From: Alex Ogrodnik <[REDACTED]>
Sent: 16 July 2019 15:57
To: Finlay Gardner [REDACTED]
Subject: Re: Application R/109/19/HH

I have recently taken on your application (R/109/19/HH) for a first floor rear extension. I have a few questions that I would appreciate if you could clarify.

Job Title
To form New
Bedroom No.4
Over Kitchen extension

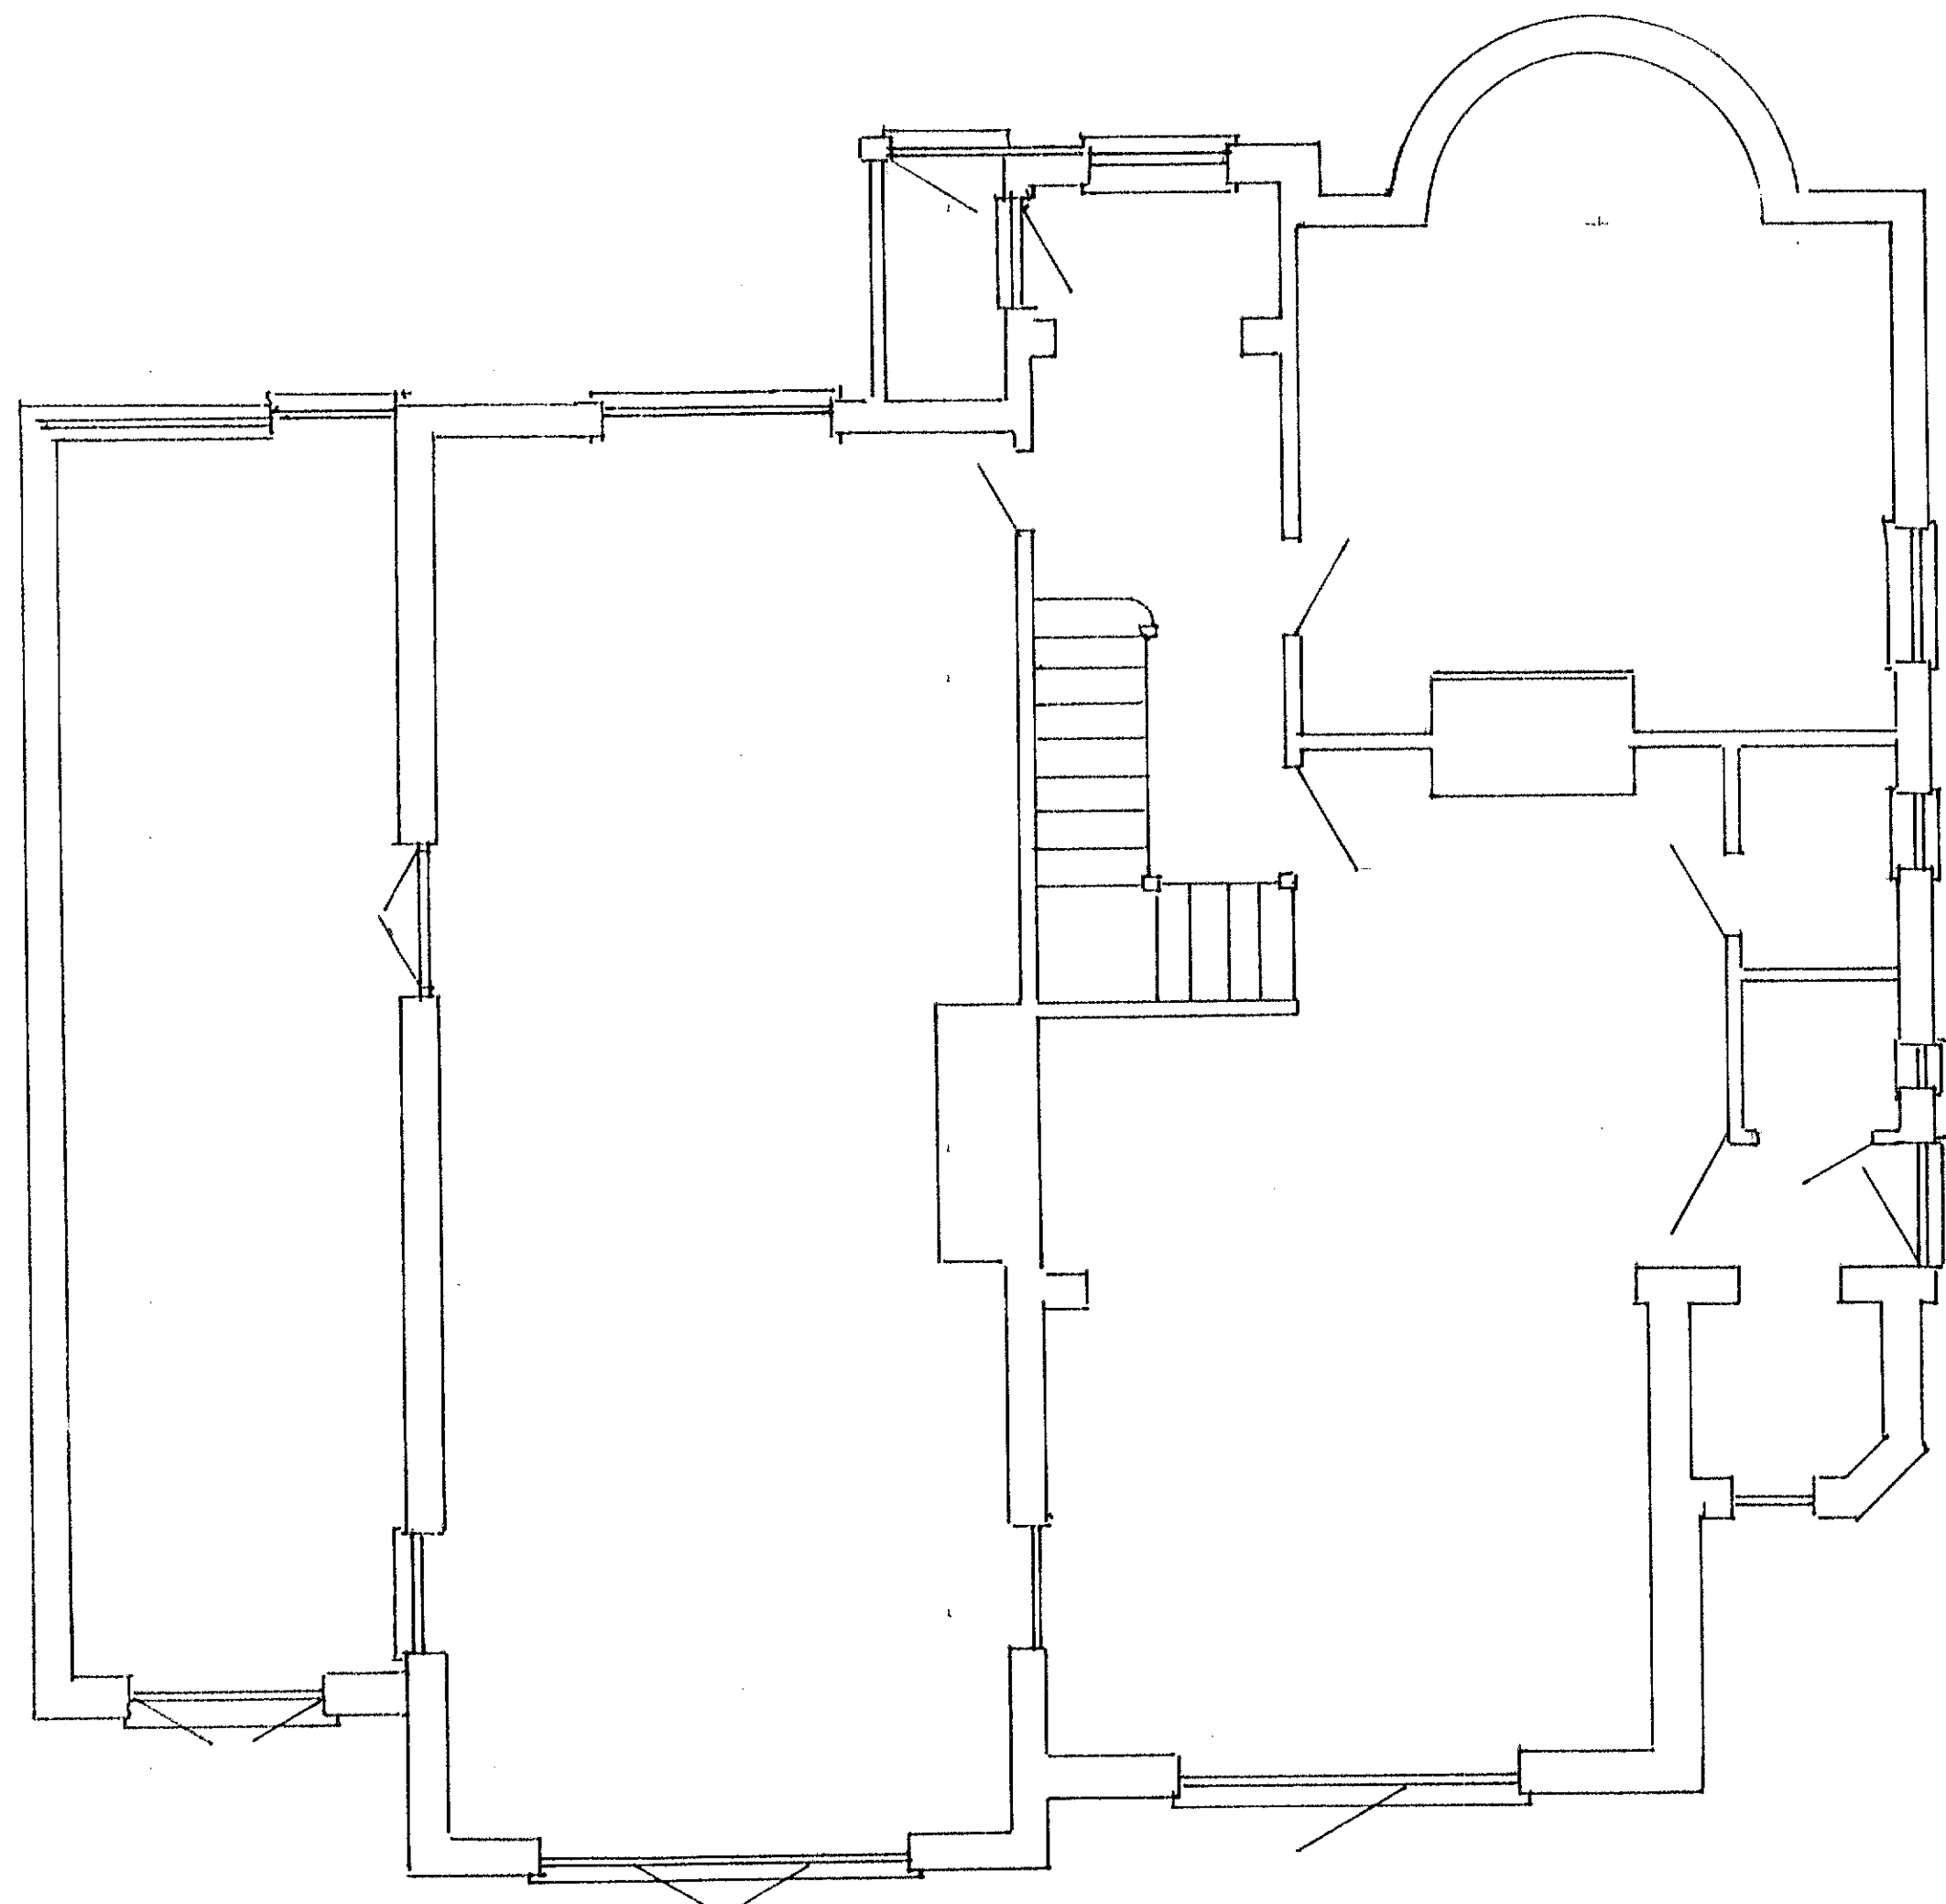
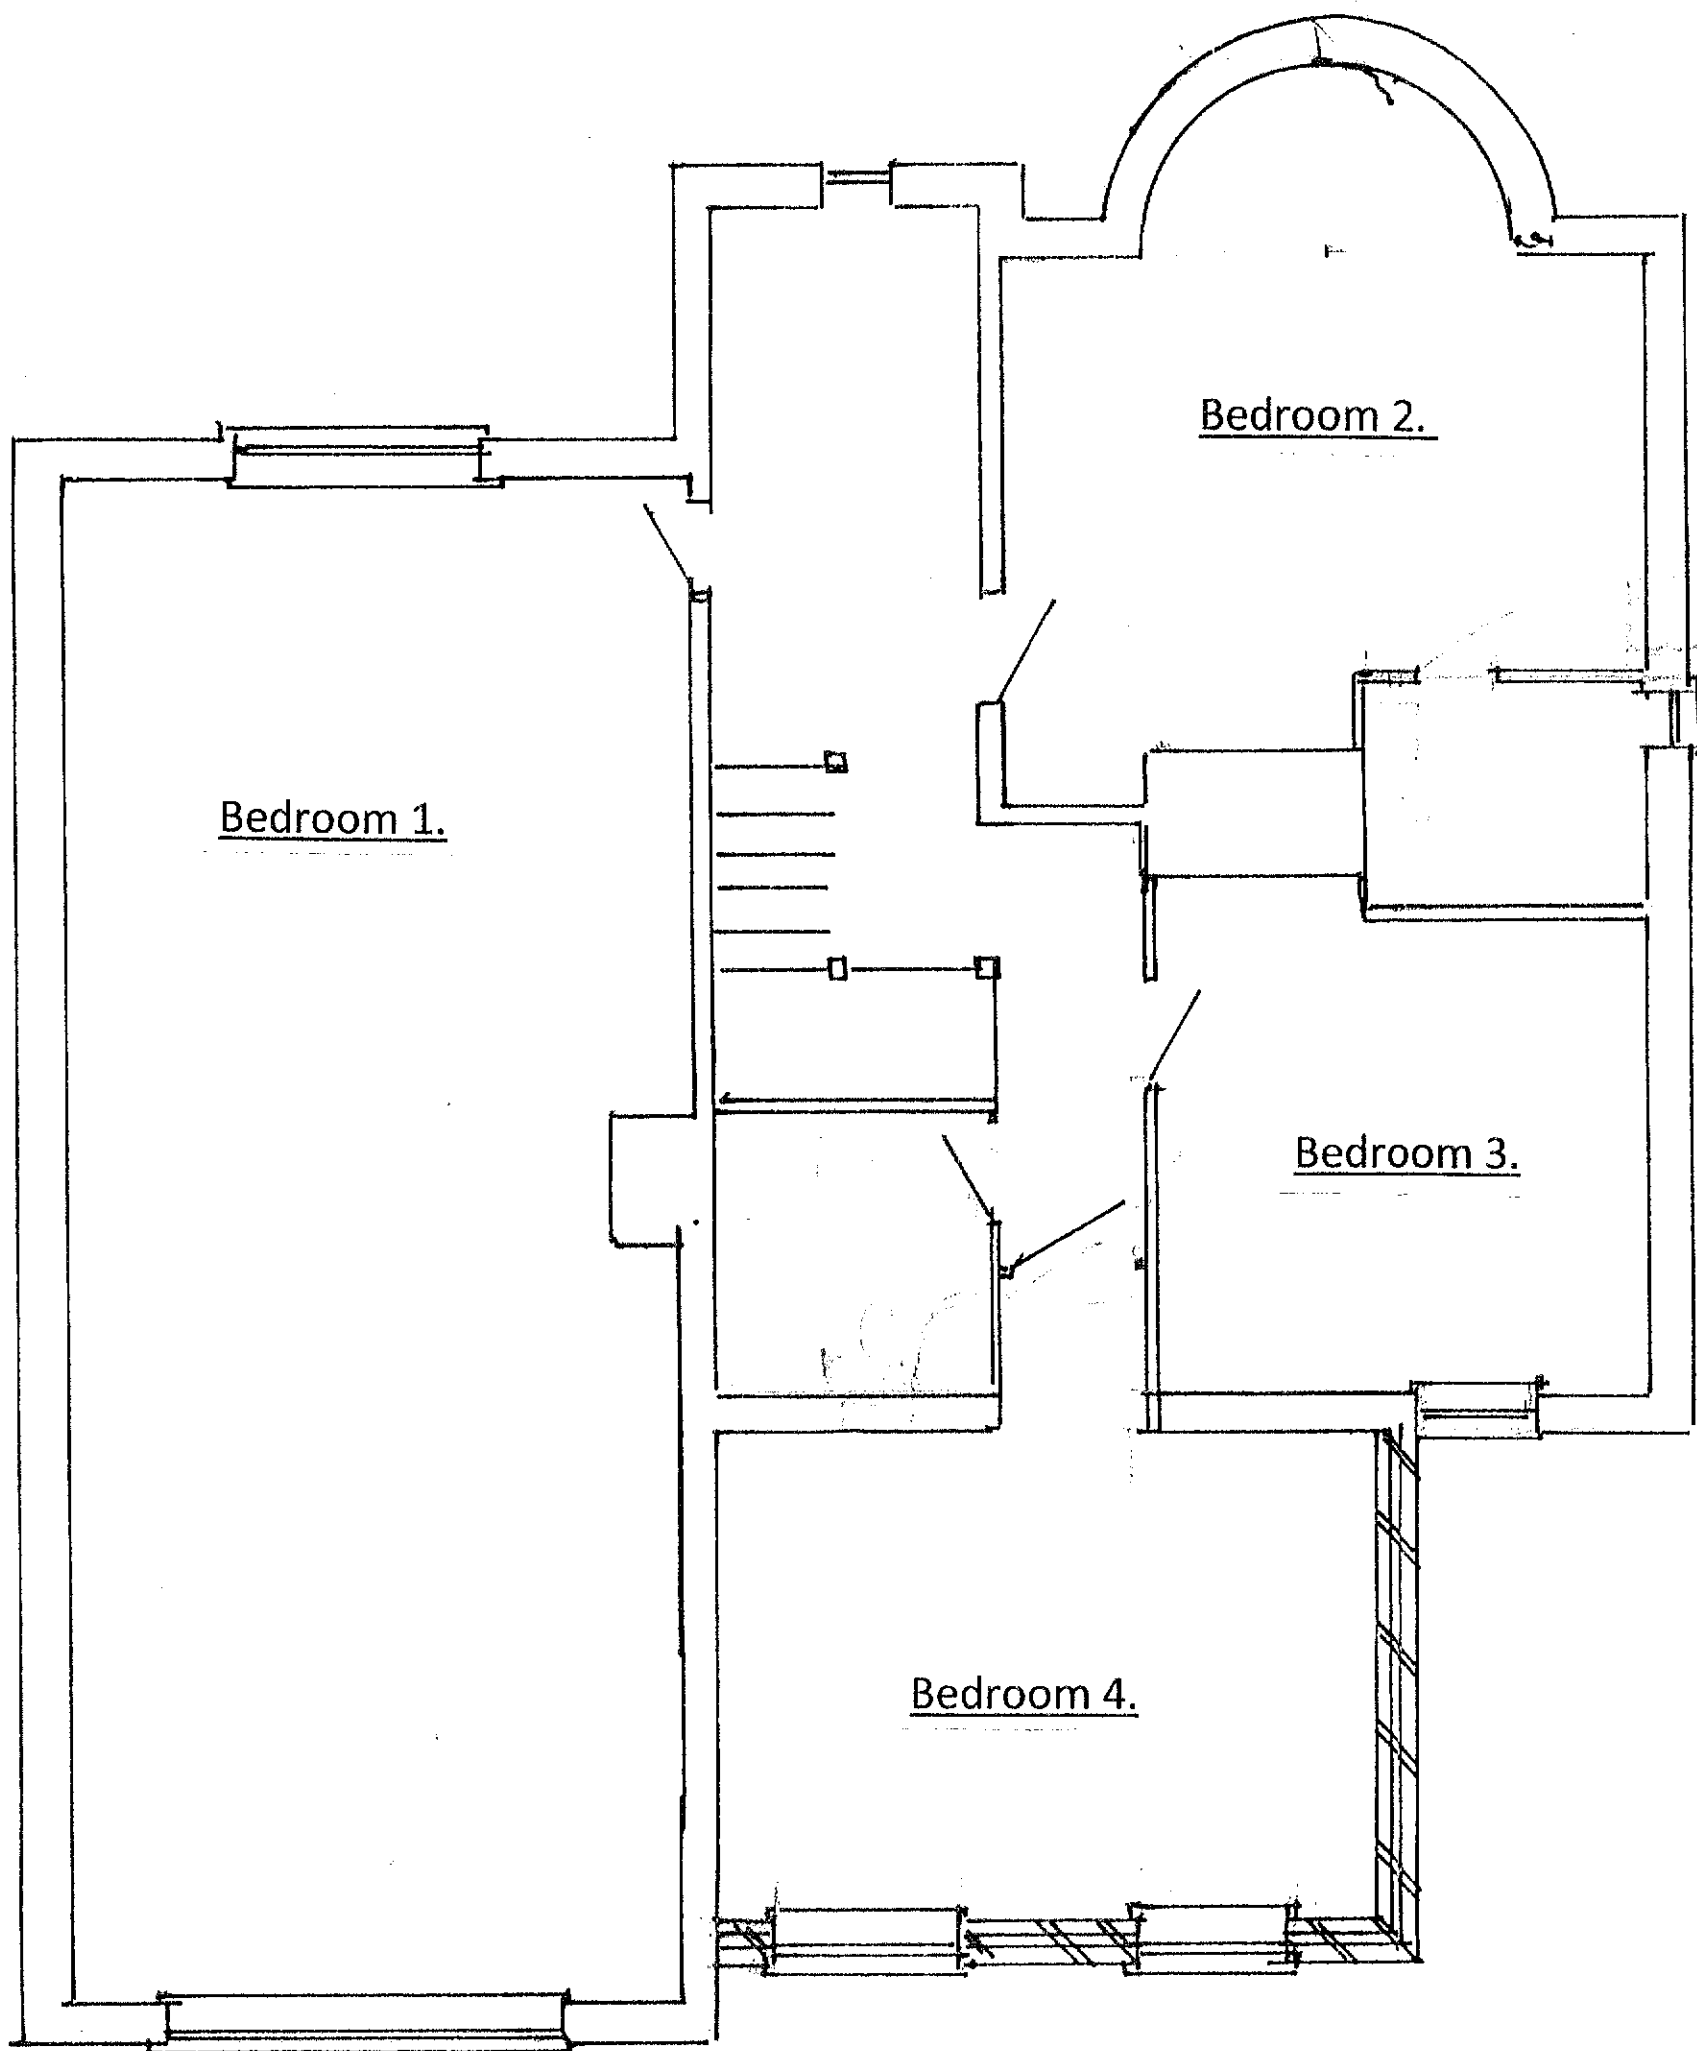
On the plans it shows the rear extension being built from the ground up making it a two storey extension as a posed to a first floor extension. On the Southern elevation there is also development and changes shown. If you could just clarify if you would like the application to include the side extension as part of the application. If you do wish for the side extension/ conservatory to be included as part of the application then we would need to re advertise the application. Any clarification would be greatly appreciated.

The rear extension ie/ Kitchen was approved in our application RH/151/16/HH and our intention was to build a bedroom over it the Kitchen extension is currently being built so it is not shown on the plans as built. the conservatory extension is also being currently built. If you think that we should need further approval please do let us know..
